Our Ref: FG/32/18/HH
Your Ref:

Town & Country Planning Act 1990 (as amended)
Town & country Planning (Development Management Procedure) (England) Order 2015
Application for Planning Permission for Works or Extension to a Dwelling

Development Reconstruction of existing front sunroom to current standards and to incorporate it with lounge/study by removing existing glazed screen/walls.
Location 55 Sea Lane Gardens Ferring

Rev.	Description	Dr'n	Chk	Date
	55 SEA LANE GARDENS, FERRING, WEST SUSSEX BN12 5EG			
	Mr & Mrs D Brooks			
Title	Reconstructed Sunroom Extension BLOCK PLAN			
Scales	1:200	Sheet Size	A3	
Drawn	DMB	Checked	Date	Feb 18
Drg. No.	55SLG-02	Revision	0

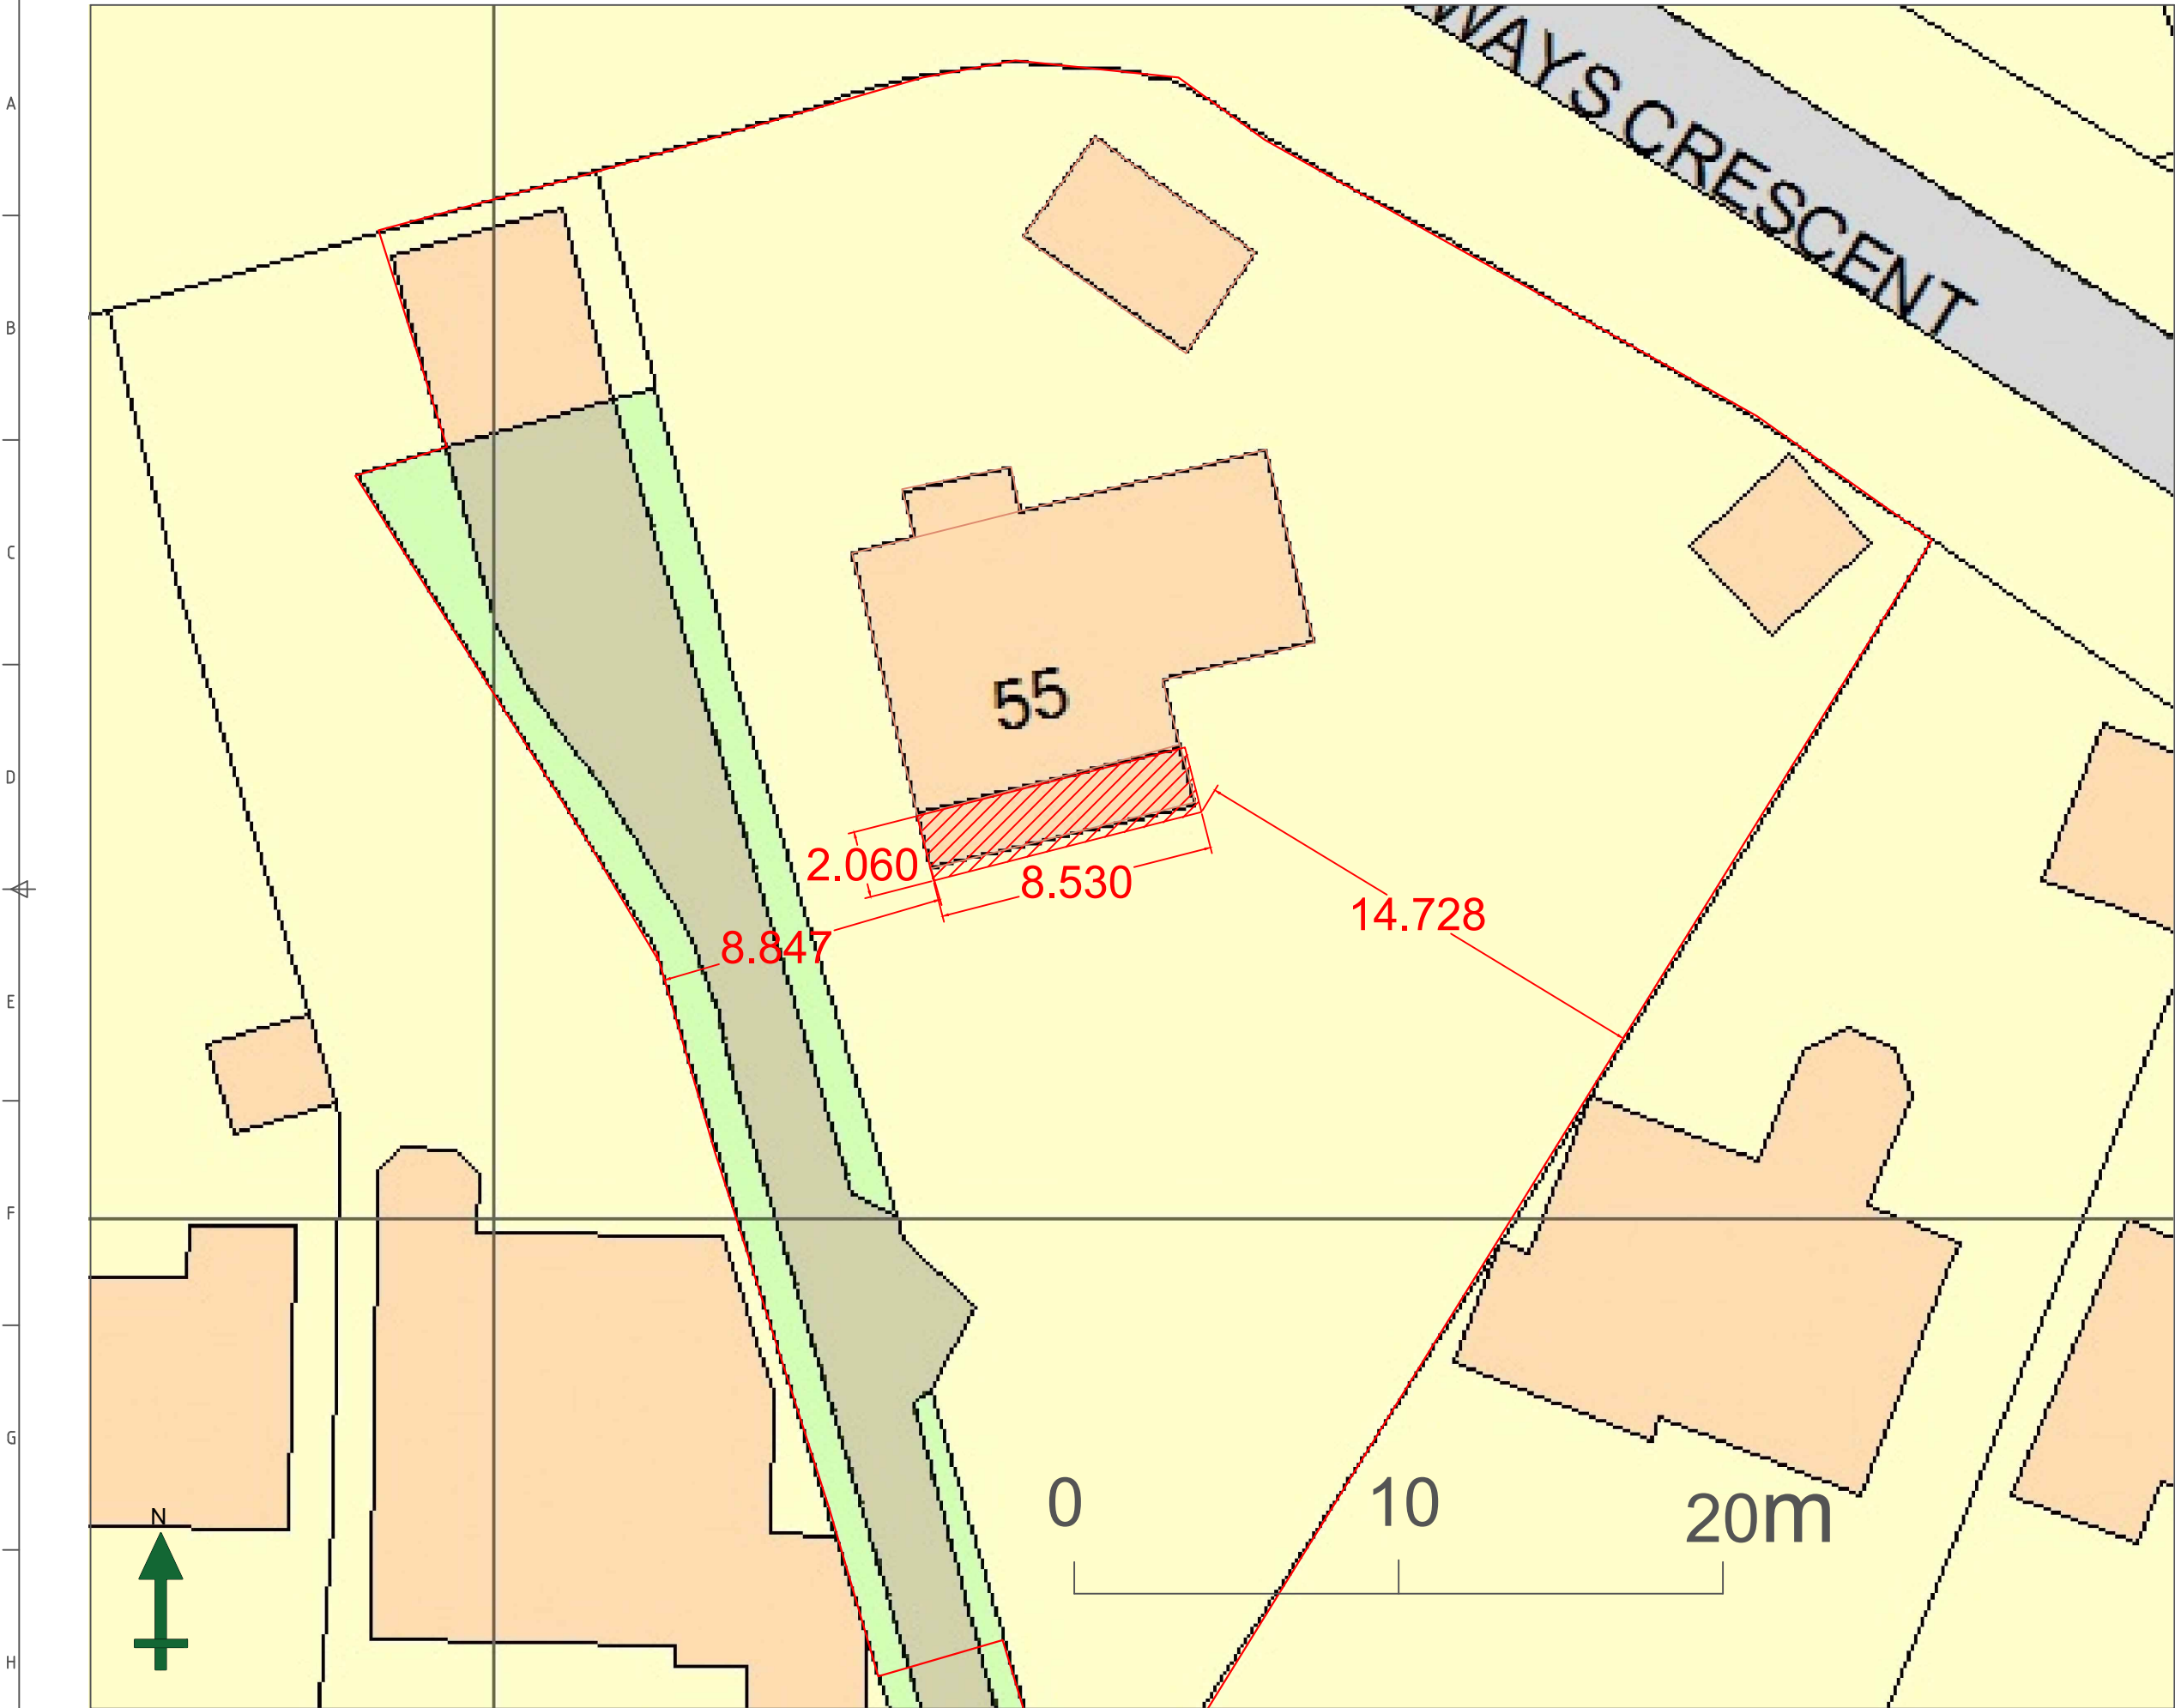
Block Plan - Amend

Please submit 1 electronic or 3 paper copies of an amended block/site plan at a scale of 1:500 or 1:200 to include the whole red edge site. Further details of what must be included on the plan can be found in the National Validation Requirements.
